Lot 36  
 Plan 2 reverse  
 Parcel: 3414203002  
 Elevation: Farmhouse  
 Basement  
 Master Plan#: M153729  
 Model: M1002

### PLOT PLAN

428 GARDEN PARK AVE. CALHAN, CO 80808  
 MAYBERRY, COLORADO SPRINGS FILING NO. 1  
 A PORTION OF SECTION 14 & 15, T 14S, R 63 W, 6TH PM  
 COLORADO SPRINGS, EL PASO COUNTY, COLORADO

**DISAPPROVED**  
 Plan Review

PLOT PLAN

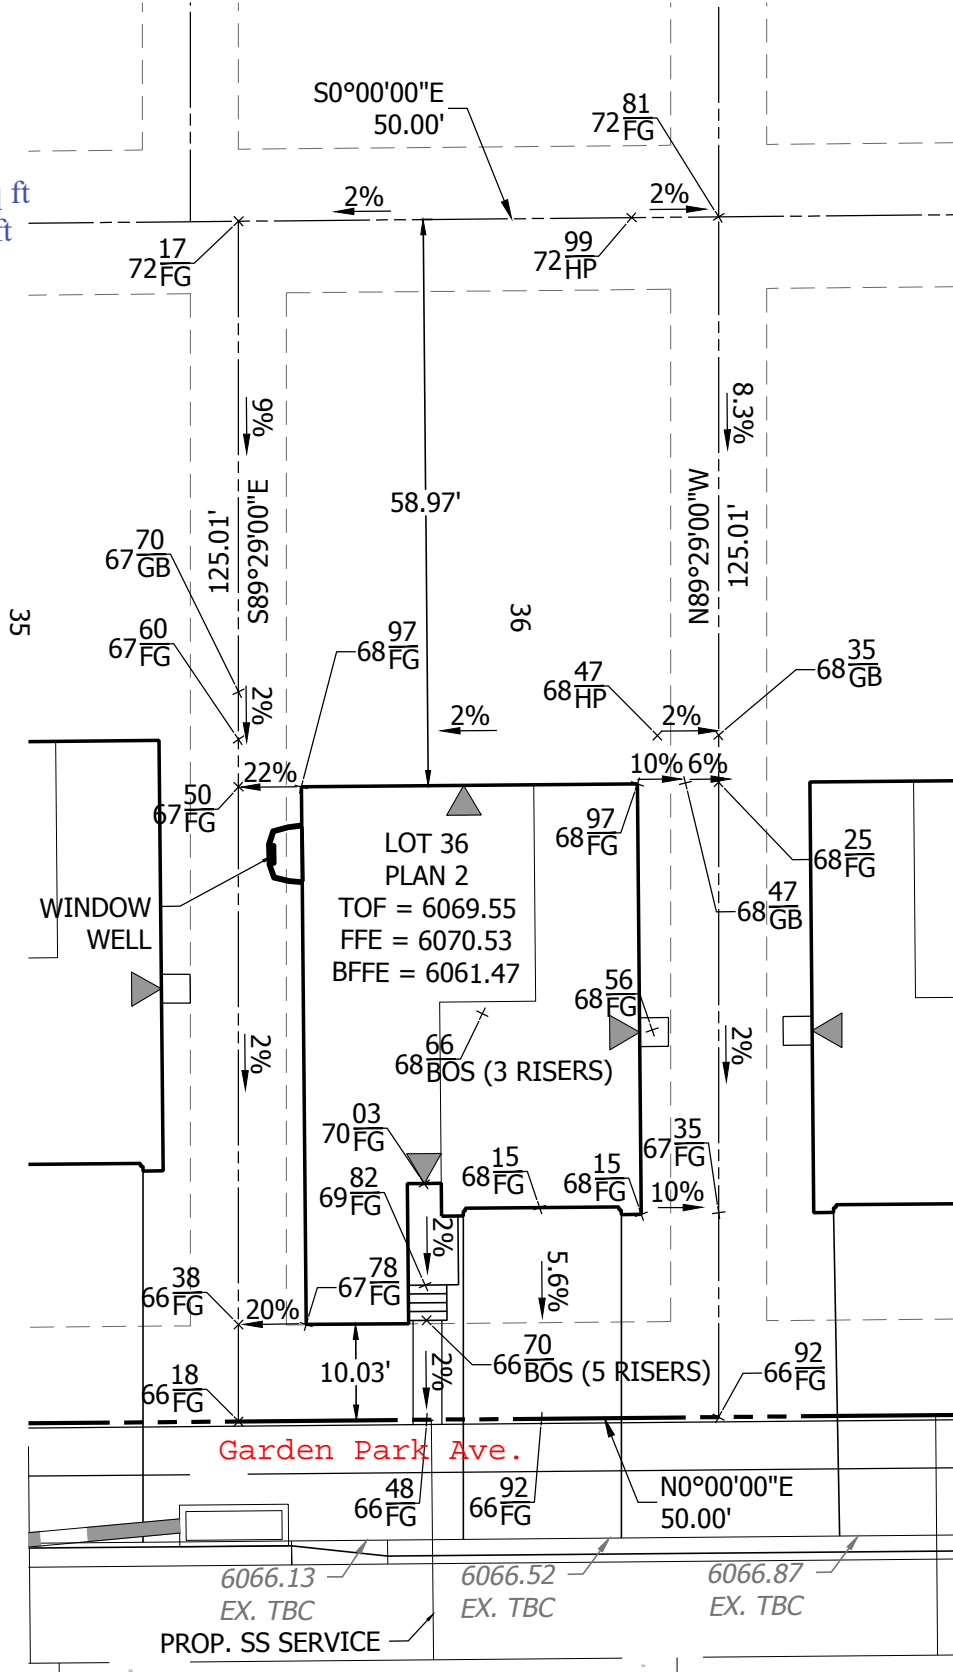
Provide site data (lot size,  
 residence size, % lot  
 coverage and average  
 building height) on all site  
 plans.
